**From:** Louise Bearcroft  
**Sent:** 25 November 2025 08:58  
**To:** DC Admin  
**Subject:** FW: Planning Application 2025/92713 and 2025/92737

2025/61/92713/E Full Final Planning Application.

I understand that the above application is interlinked with application 2025/44/92737/E,  
I have serious concerns regarding this as follows:-

Drainage Layout

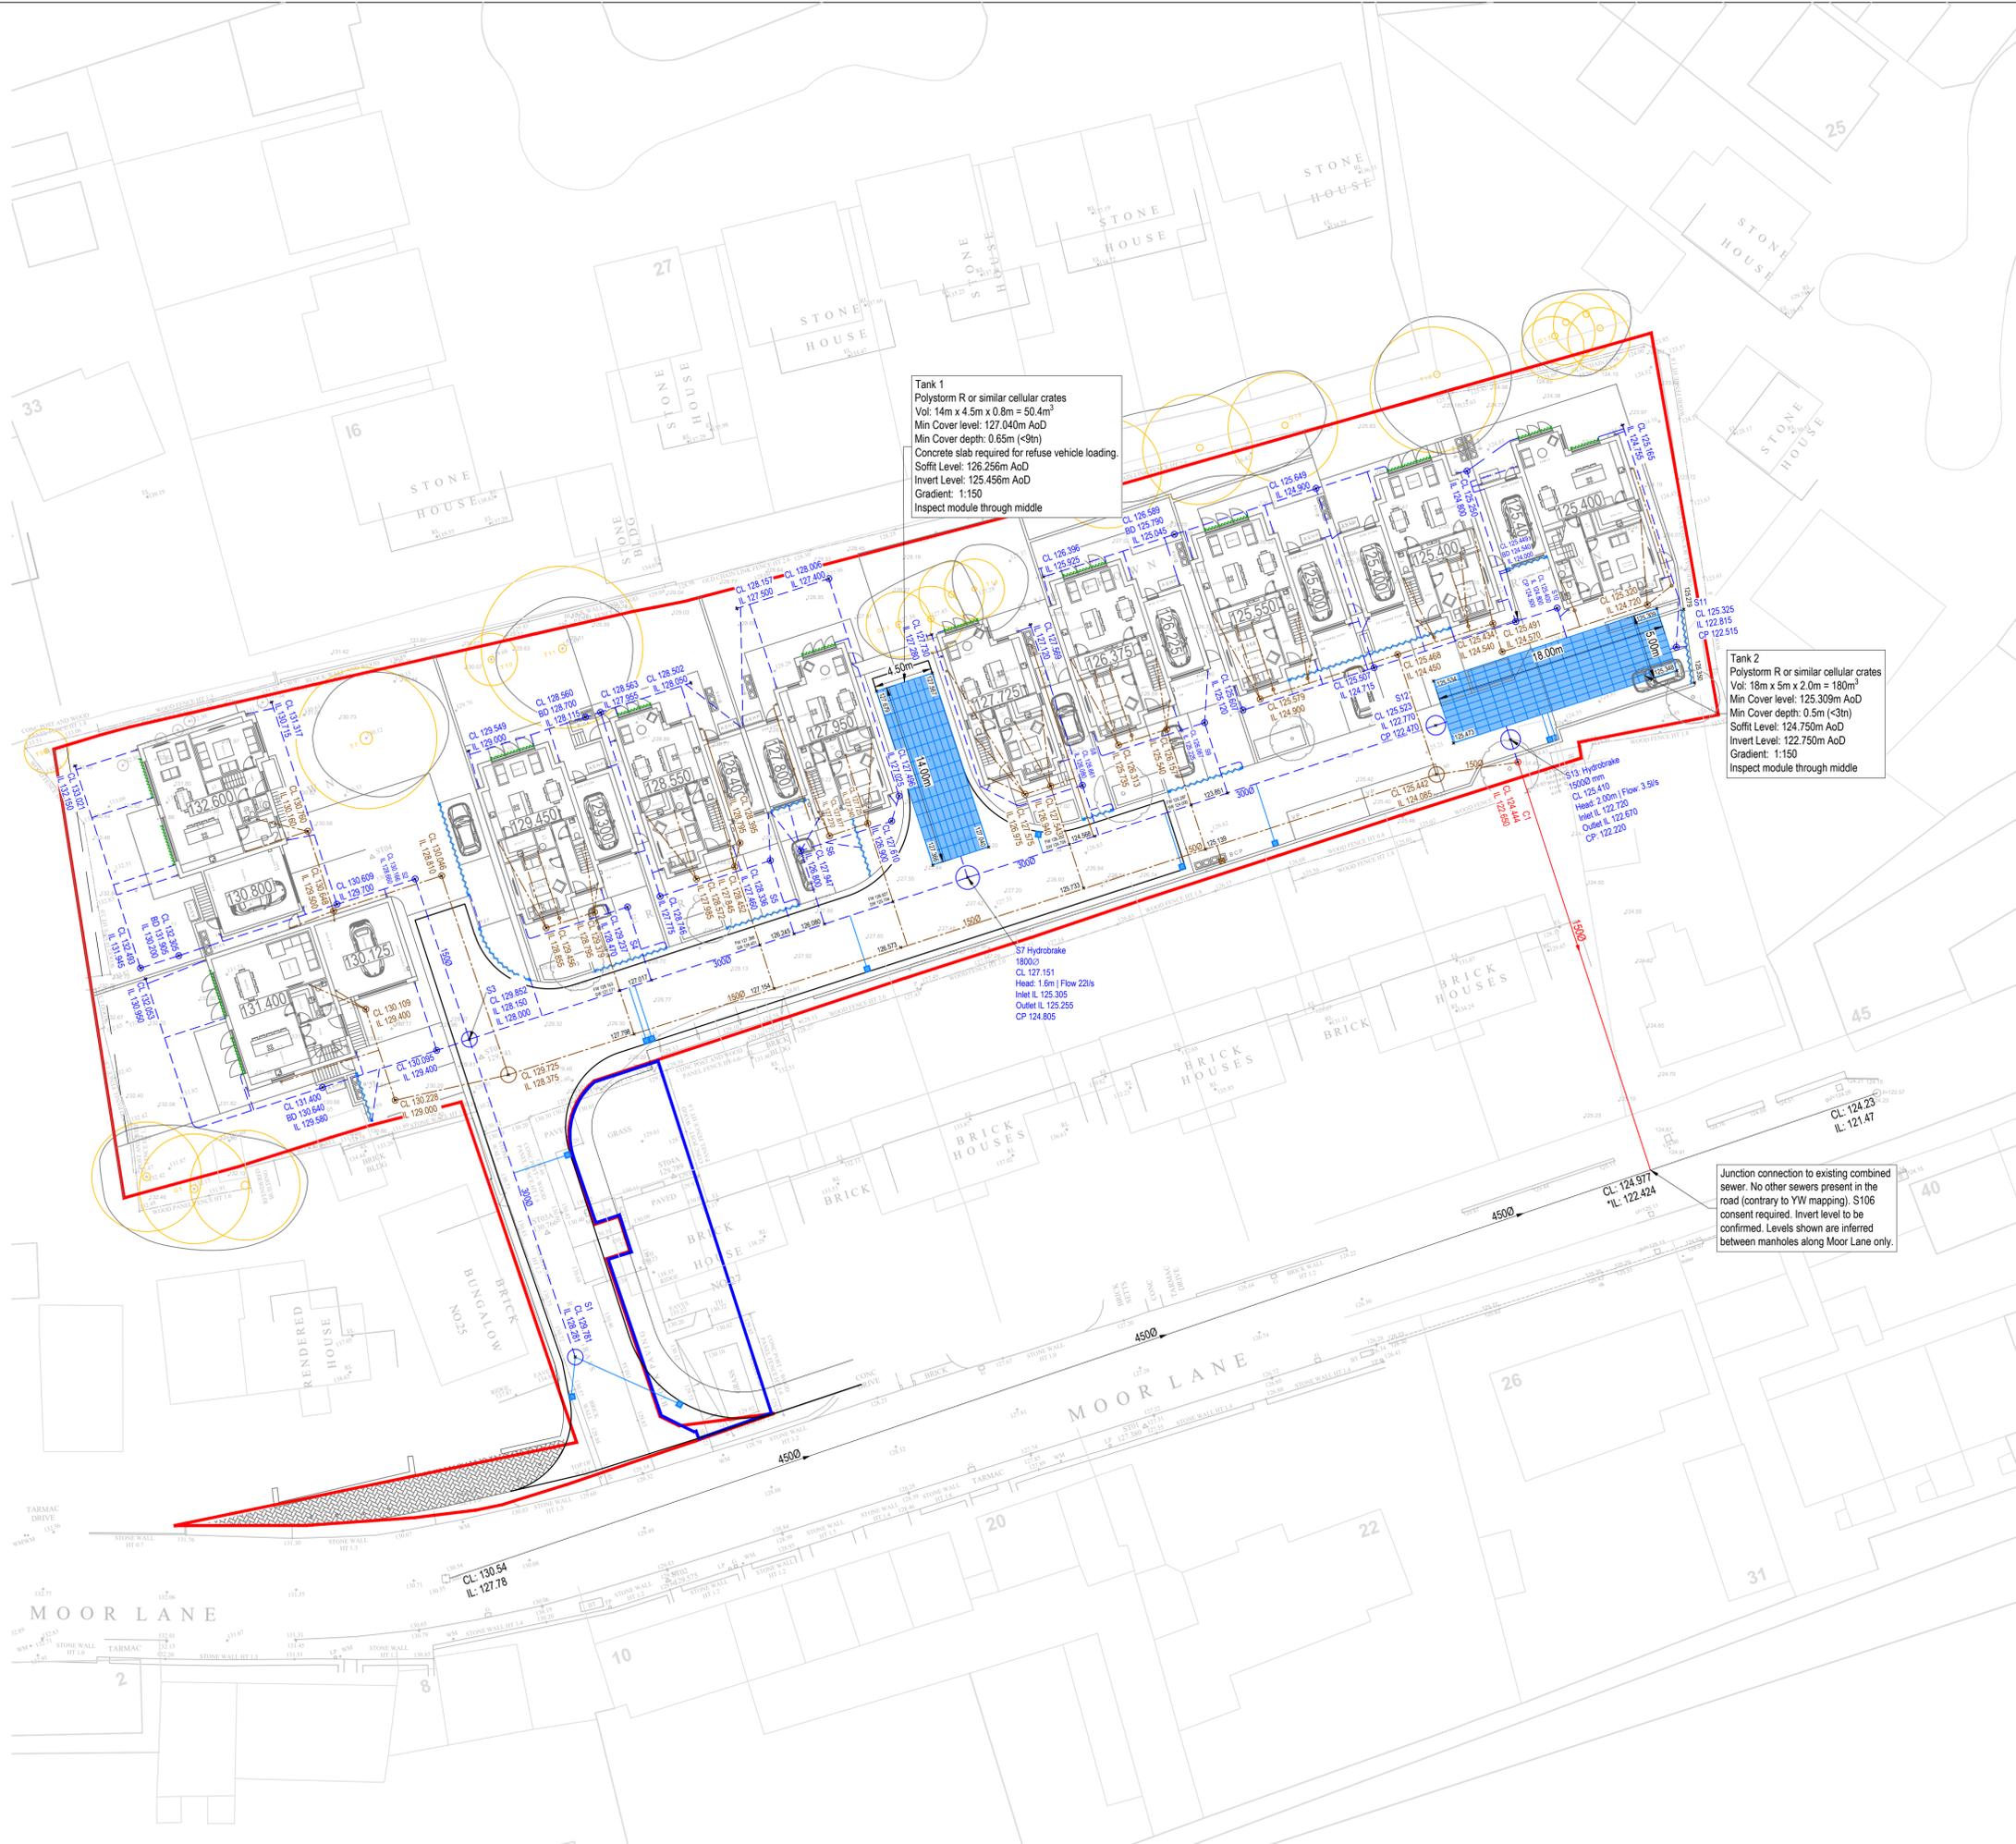
The drainage plan shows 2 underground installations, which are buried under the building site. These buried installations are designed to control surface flood water.

They are situated halfway down the site. If this system fails, properties to the side and below these installations, on the site boundary, will be more prone to flooding. The plans appear to have a flood route directed towards Moor Lane and Summerdale.
